RE: SUBMISSION TO SSD-48028209, Residential development with infill affordable housing
Address: 16-24 Lord Street & 21-27 Roseville Avenue, Roseville

ATTACHMENT 1

Ku-ring-gai Council's objection to SSD- 78996460, 16-24 Lord Street & 21-27 Roseville Avenue, Roseville

APPENDIX 2: SHADOW DIAGRAMS + SUN EYE VIEW DRAWINGS

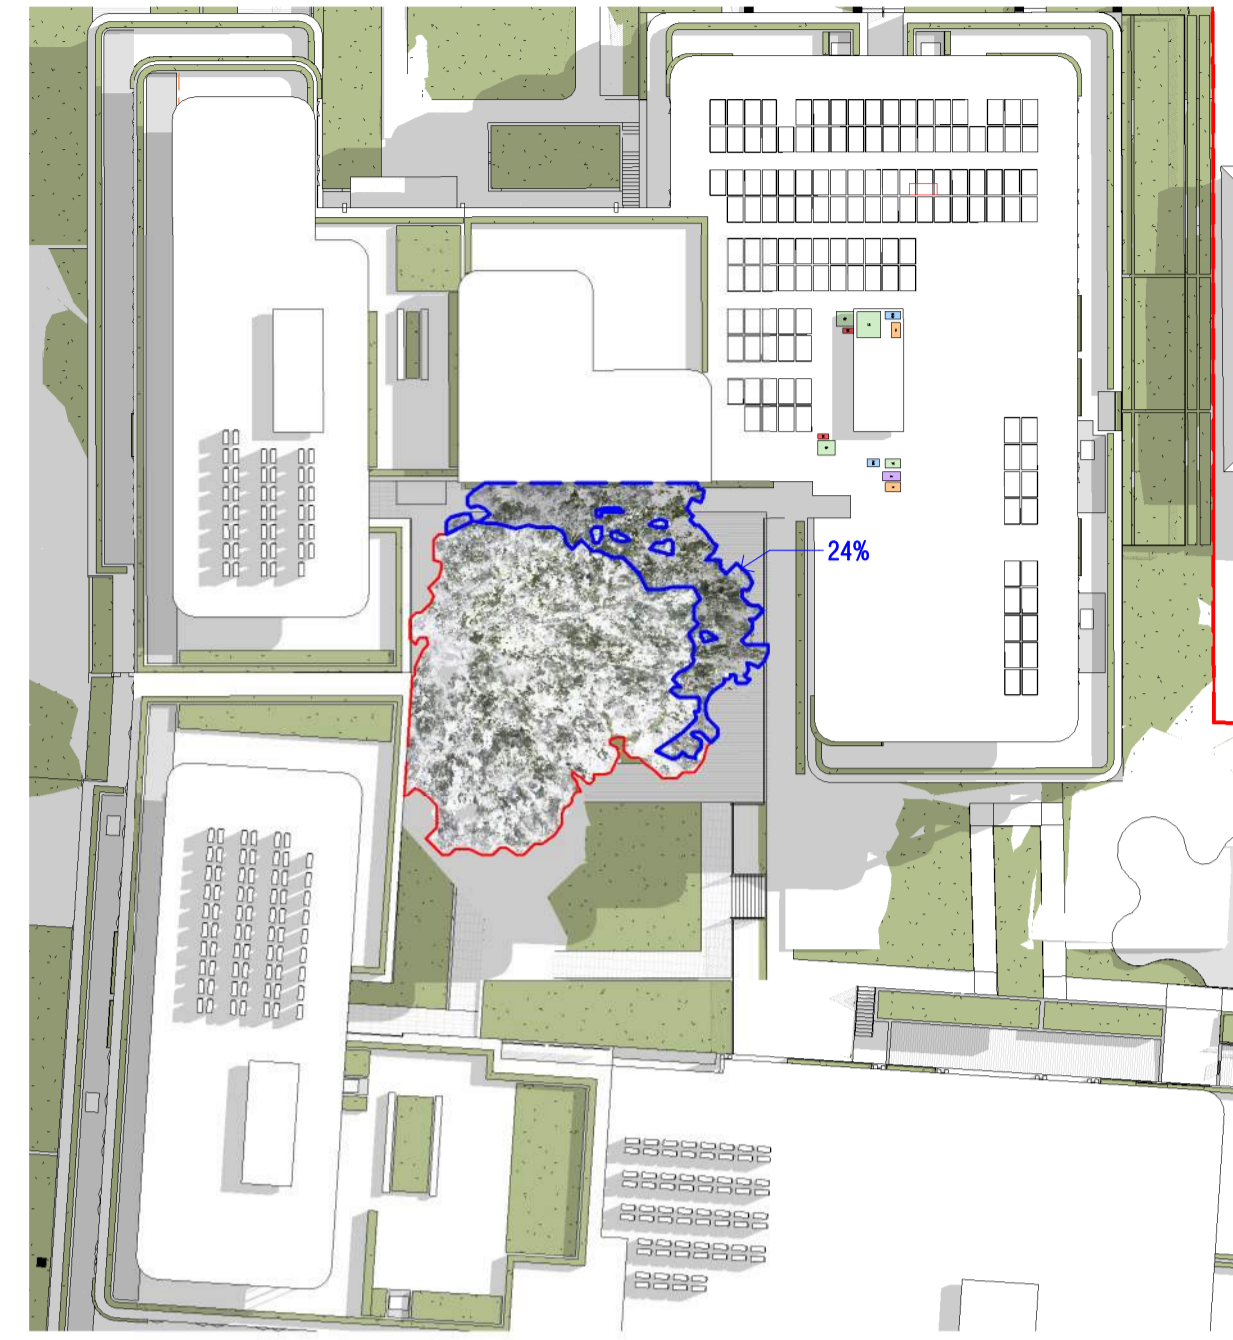
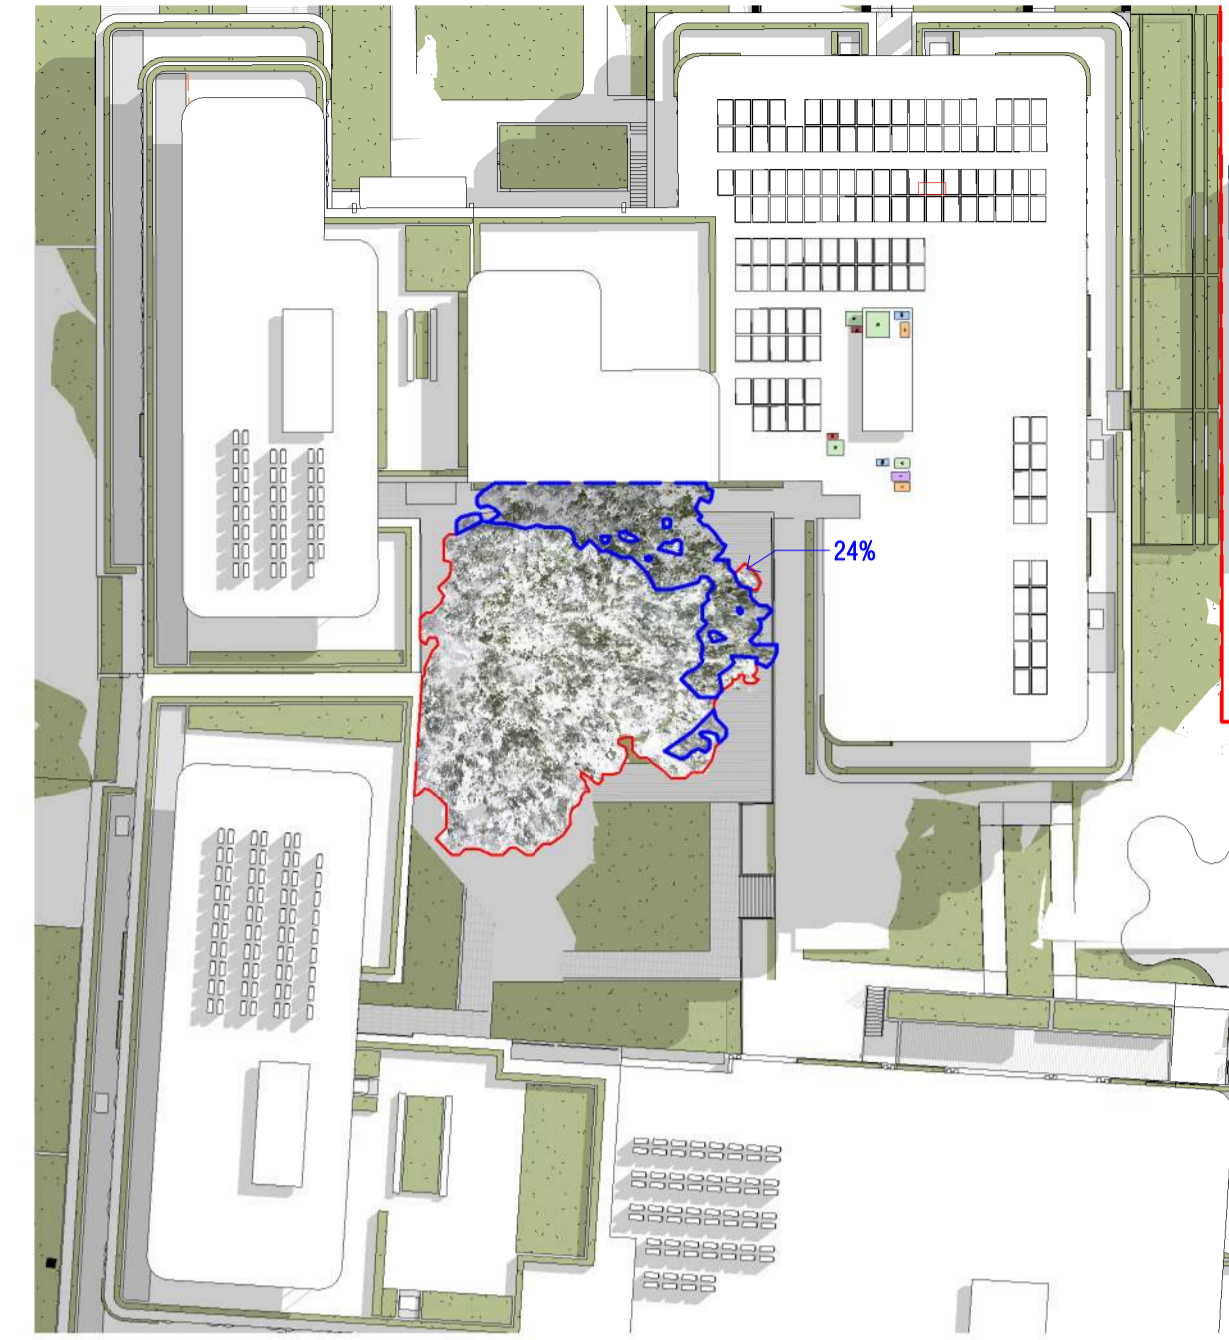
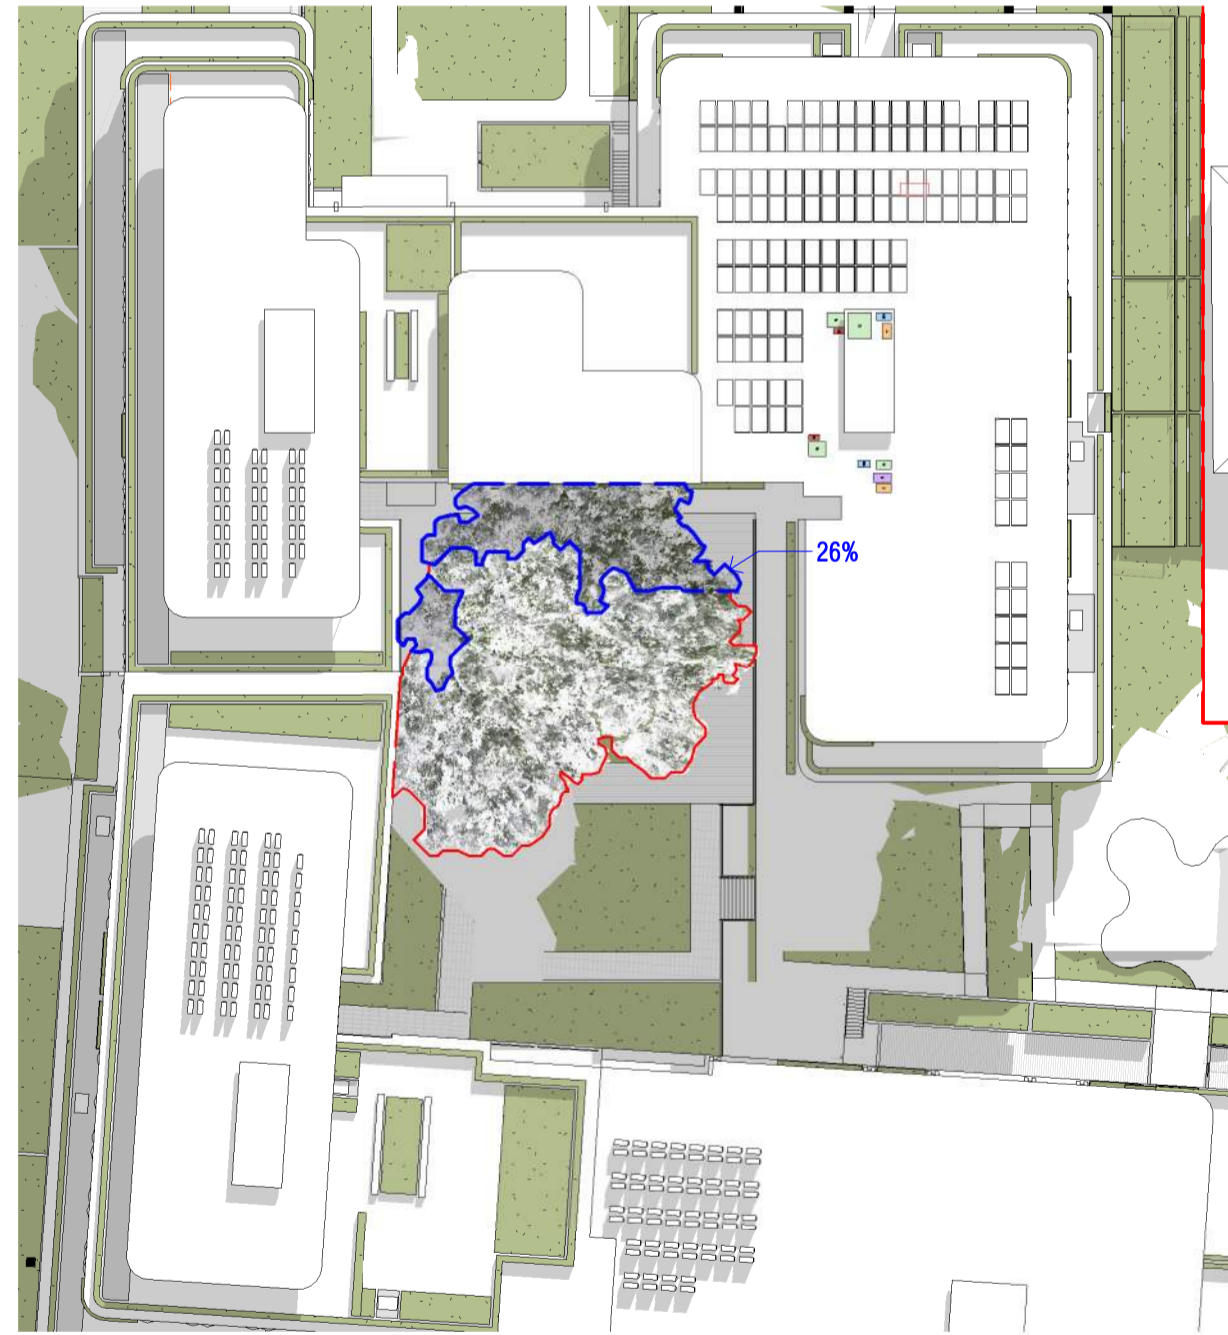
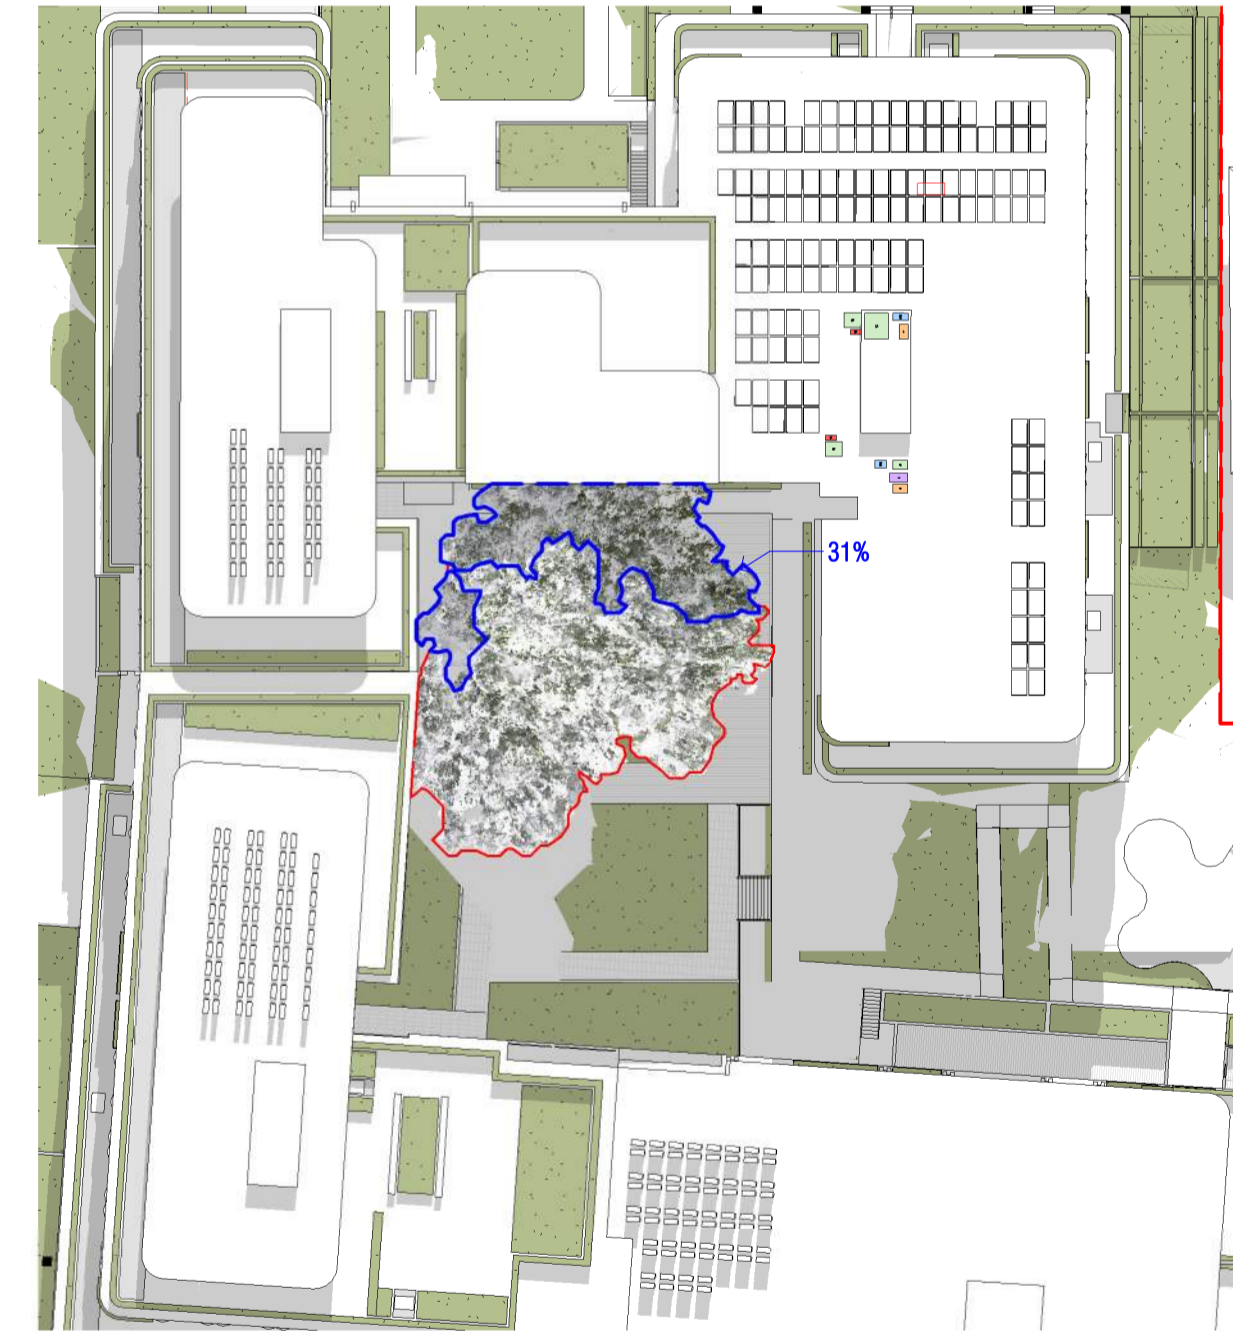
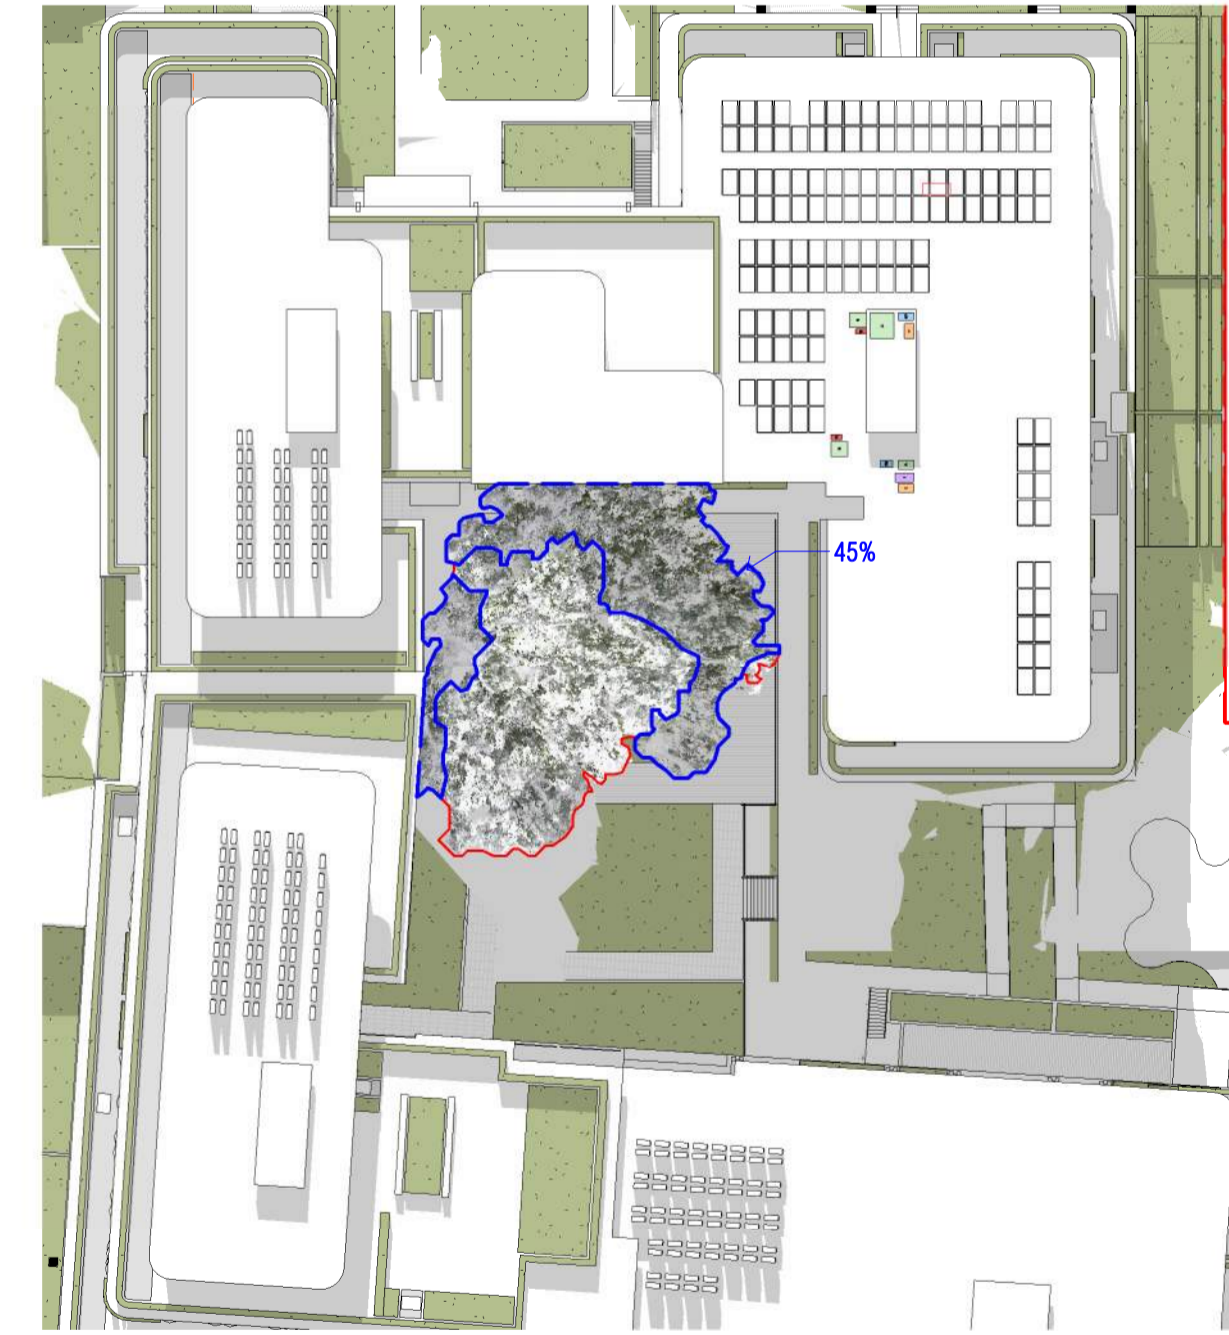
- The areas that breach the height plane, in particular the uppermost western edge and the uppermost southeastern and southwestern corners, appear that they will have some overshadowing impact on properties to the immediate west and to the south across Lord Street.
- The proposal is inconsistent with SEPPH Aim 150(b)(ii) and (iii) to 'deliver mid-rise residential flat buildings... that are of appropriate bulk and scale and provide amenity and liveability.

- They do not sufficiently demonstrate that adverse overshadowing impacts will not be caused by the non-compliant building height.
- The non-compliant elements are not suitably set back from the boundaries of the site and result in a breach to the building setback controls under the ADG and the Ku-ring-gai Development Control Plan (KDCP).
